## **Condition Discharge / Variation Document for**

### **Planning Application Ref 21/03178/FUL**

RE-SUBMISSION OF PREVIOUSLY APPROVED  
REPLACEMENT DWELLING FOLLOWING  
DEMOLITION OF EXISTING DWELLING -  
INCORPORATING MINOR AMENDMENTS (Re-  
submission of 19/02568/FUL)

Tollerton Lodge Tollerton Lane Tollerton  
Nottingham Nottinghamshire NG12 4FR

Proposed Tree Protection Layout (1:200)

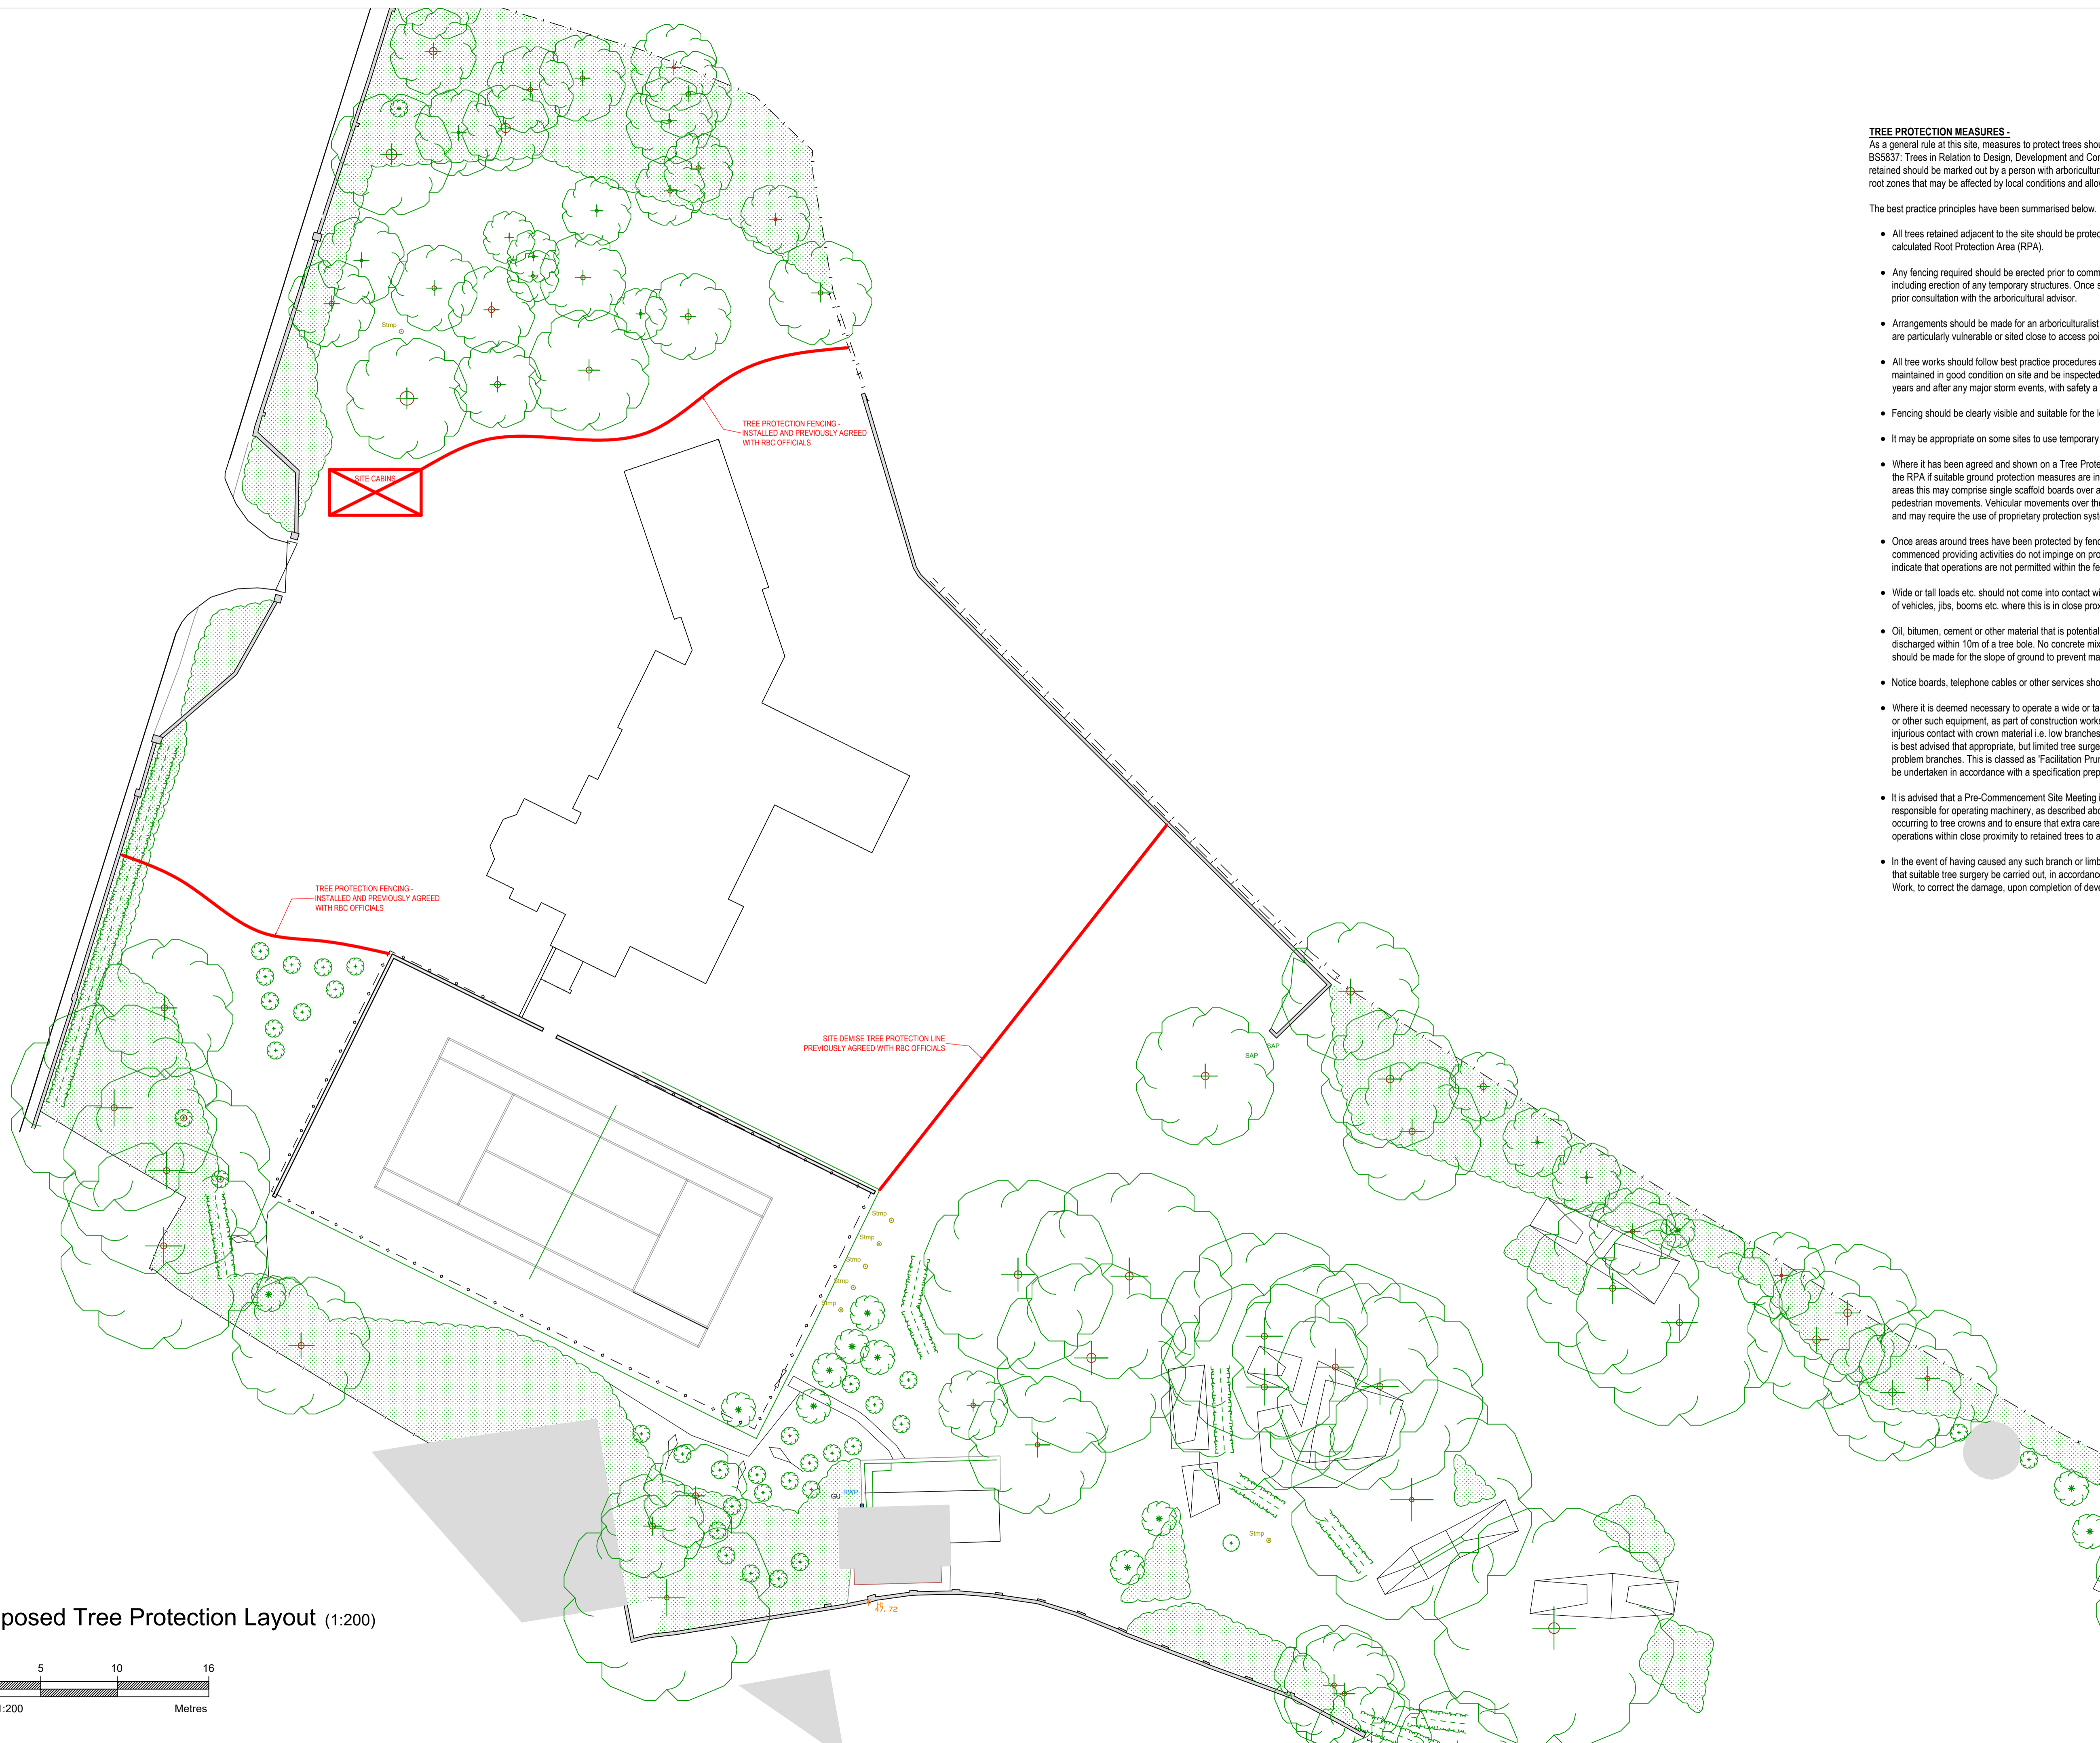
No operations shall commence on site until the existing trees and/or hedges which are to be retained have been protected in accordance with details in (line with BS5837) to be approved in writing by the Borough Council and that protection shall be retained for the duration of the construction period. No materials, machinery or vehicles are to be stored or temporary buildings erected within the perimeter of the fence, nor is any excavation work to be undertaken within the confines of the fence without the written approval of the Borough Council. No changes of ground level shall be made within the protected area without the written approval of the Borough Council.

The existing trees and hedges which are to be retained have been protected in accordance with details in line with BS5837 and these protection measures will remain in place for the duration of the construction period. No materials, machinery or vehicles are to be stored or temporary buildings erected within the perimeter of the fence, nor is any excavation work to be undertaken within the confines of the fence without the written approval of the Borough Council.

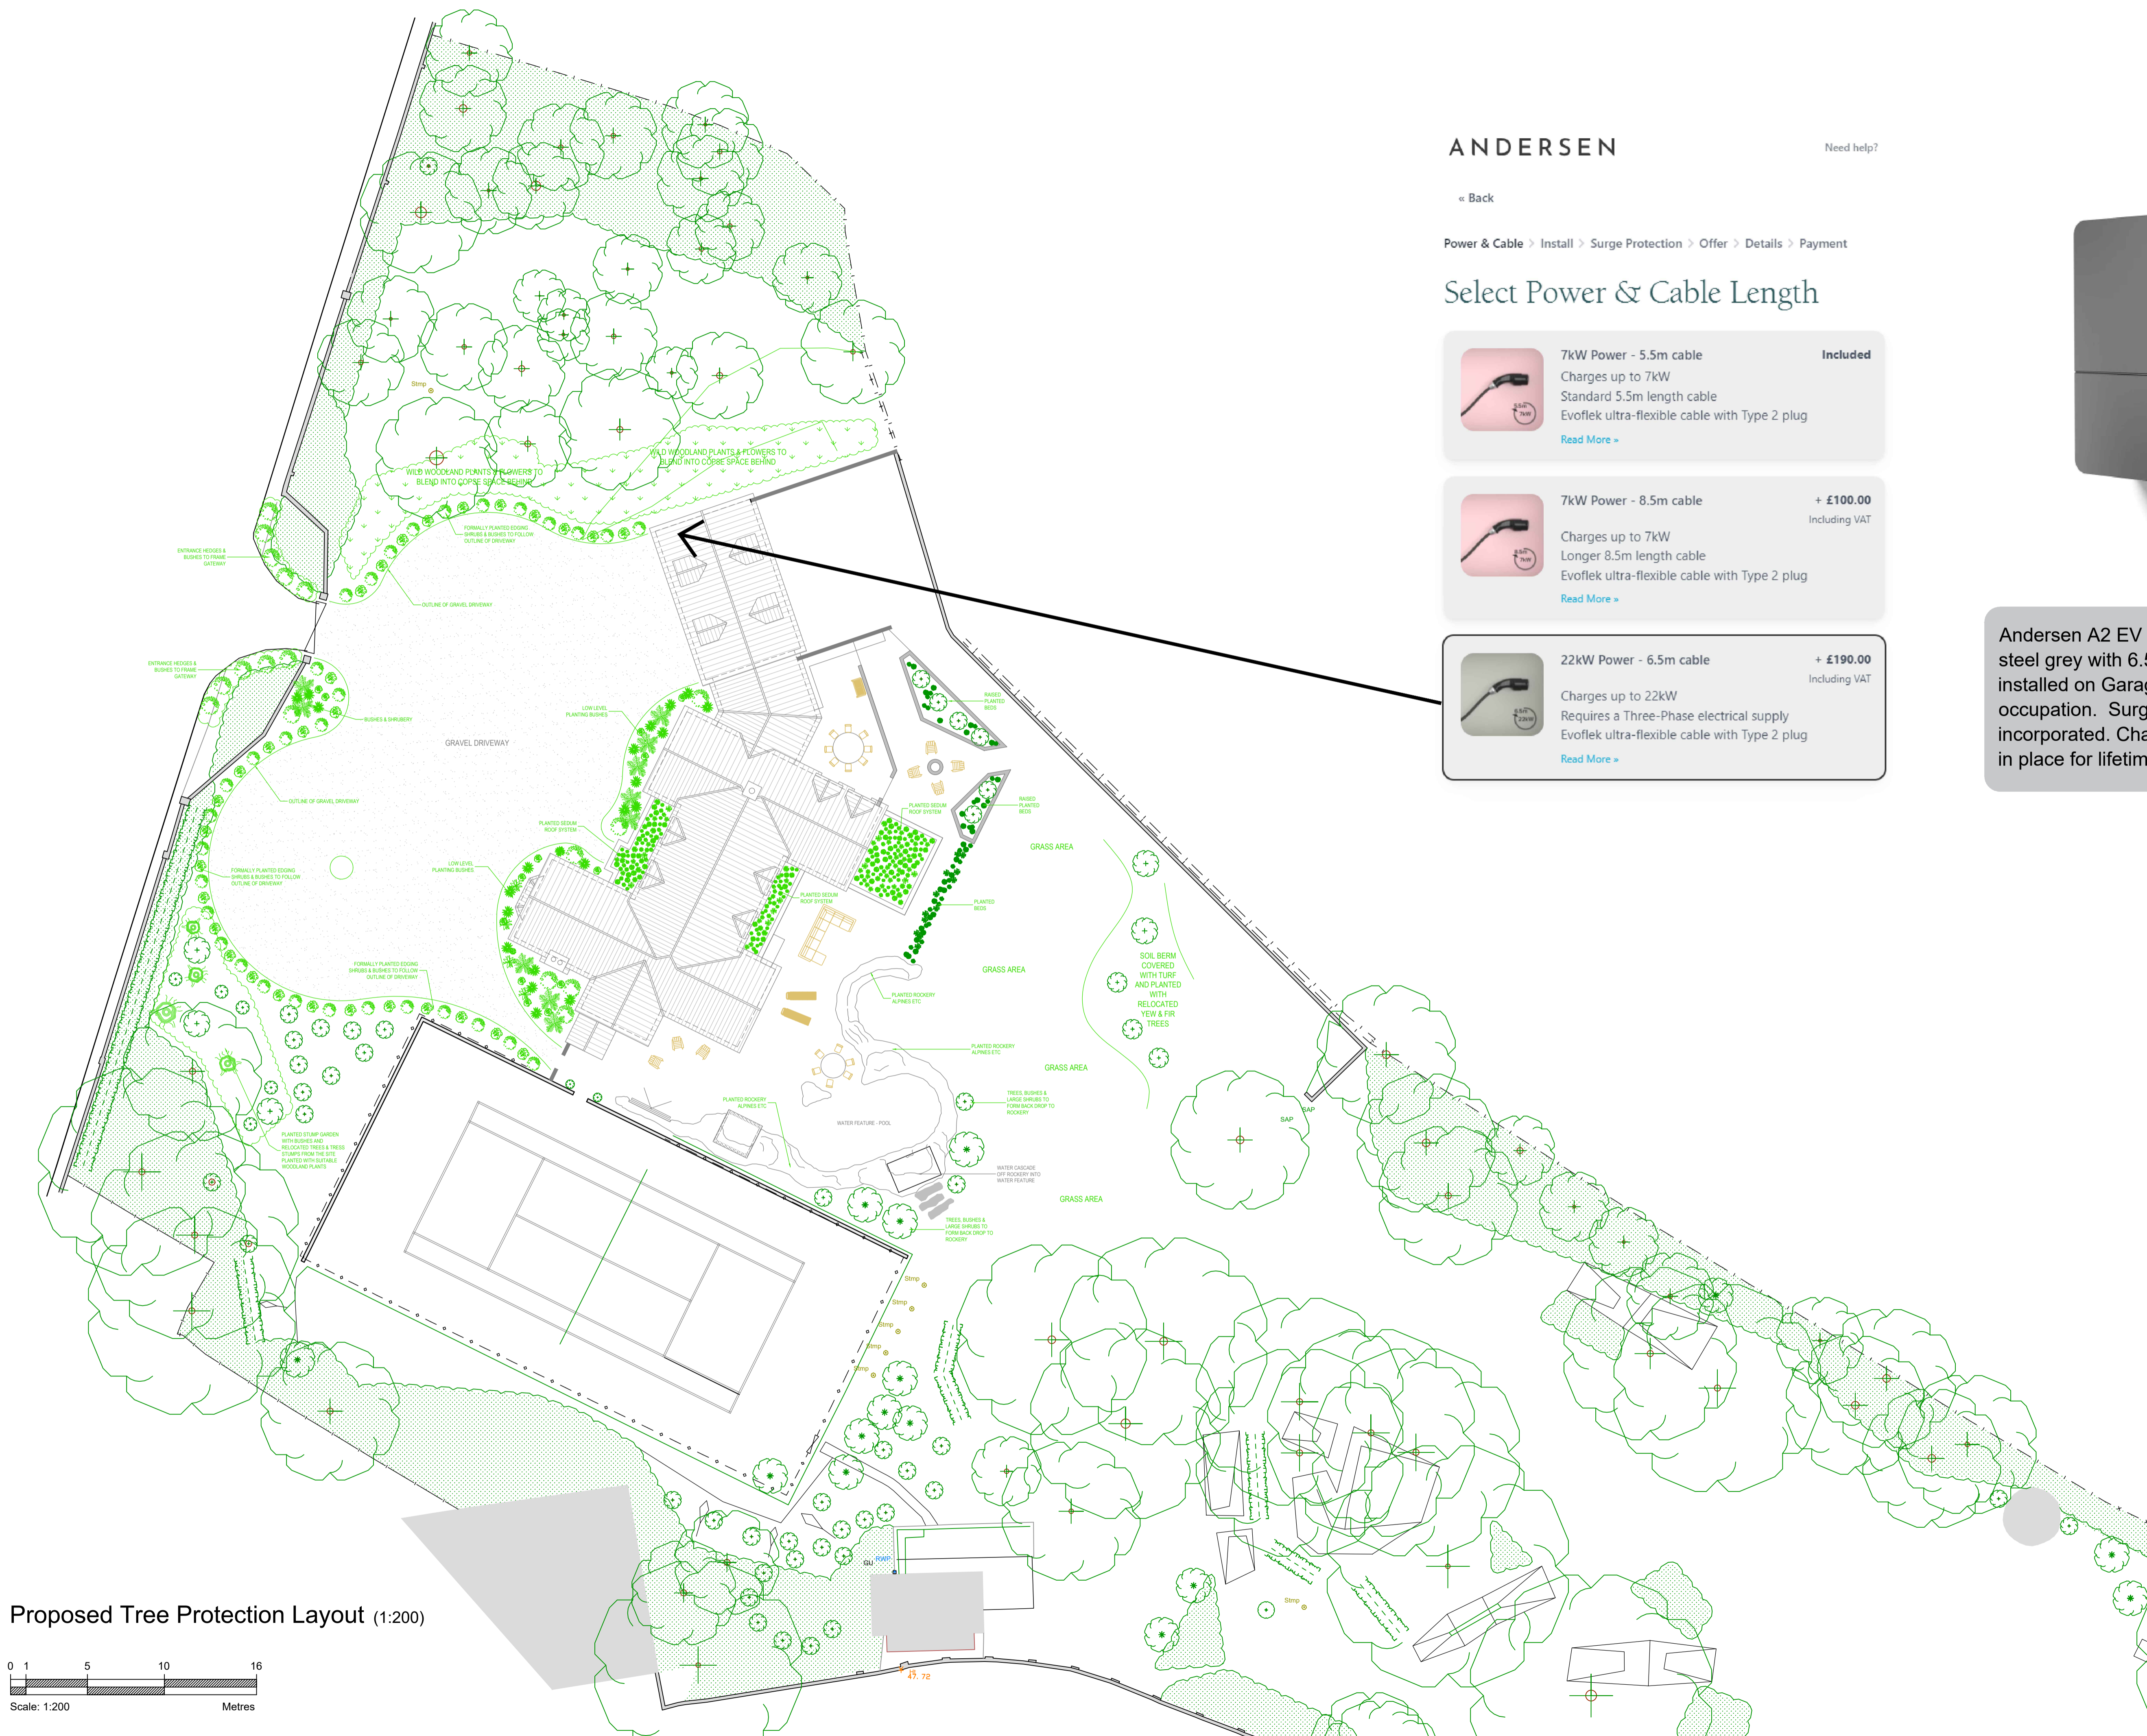
Prior to the construction of the dwelling proceeding above damp proof course level, a scheme for the provision of electric vehicle charging points shall be submitted to and approved by the Borough Council. The scheme shall provide details of the provision of electric vehicle charging points to serve the dwelling on the site. Thereafter, the dwelling shall not be occupied until such time as it has been serviced with the appropriate electric vehicle charging infrastructure, where practicable, in accordance with the agreed scheme and the apparatus shall be retained for the lifetime of the development.

An Electric vehicle charging point shall be installed in accordance with details submitted on Drawing Ref 408 VEHICLE CHARGING DETAILS prior to occupation. The electric charging point shall be retained for the lifetime of the development.
